November 14, 1955

At 529 Congress St.—Alterations for Mines Bros. Co.,

AP 529 Congress St.—Alteration of store front for Kines Bros.

AP 529 Congress St.--Alteration of store front for Rines Bros.

DETAILS AT TOPS OF CONGRESS ST. COLUMNS

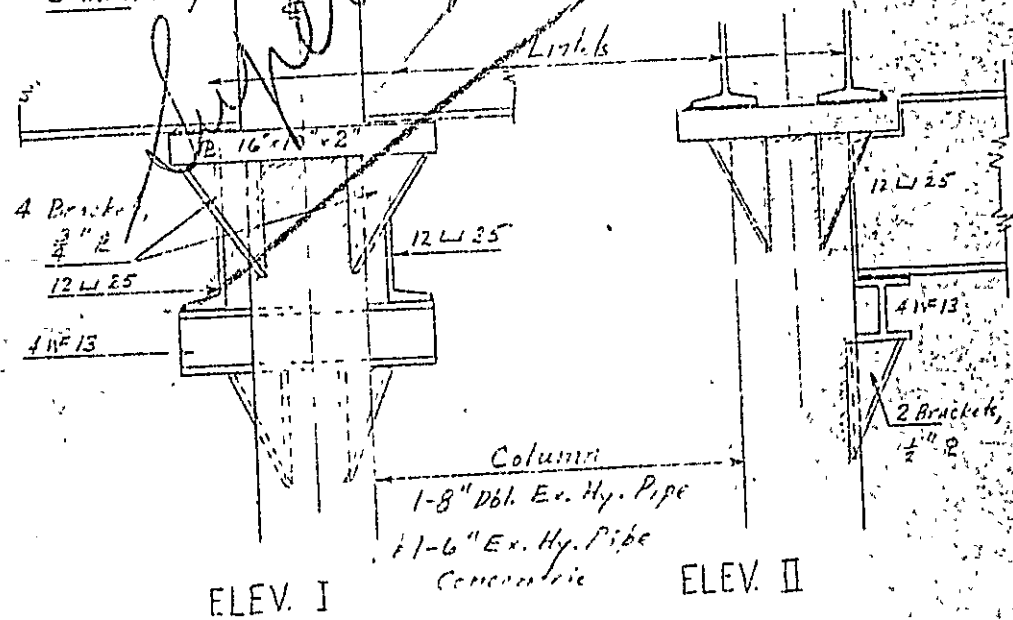
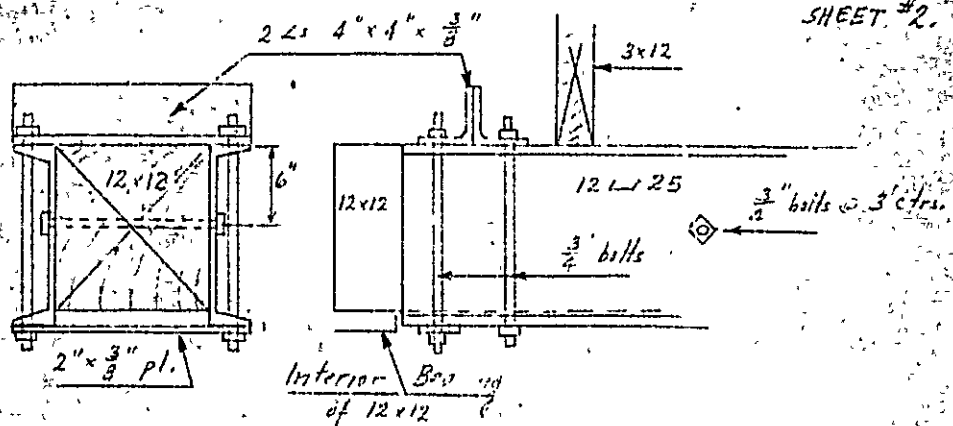
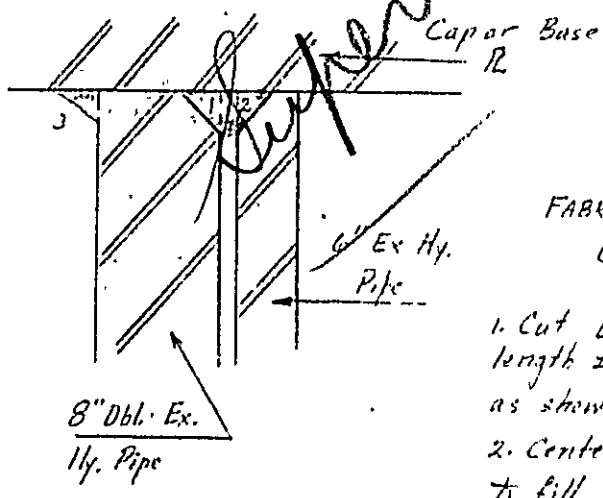
✓ The 12" x 12" timbers carrying second floor loads to the existing pilasters are not long enough to obtain direct bearing on the new Lally columns. The architect's most recent revision shows this beam bolted with 4 3/4" bolts to two channels which extend to the Lallys. These bolts do not appear to me to be adequate to develop, as they should, the allowable beam reaction.

✓ Depending, of course, upon the assumptions made as to the weights of the existing walls, it is possible that the smaller Lally columns, eight-5/8" extra heavy-weight, are not entirely adequate to carry the loads to which they would be subject. I would be interested to see the architect's figures on the loads which these smaller Lally columns will be called upon to support. My own figures leave some doubt in my mind as to the adequacy of anything less than 10" Lally columns.
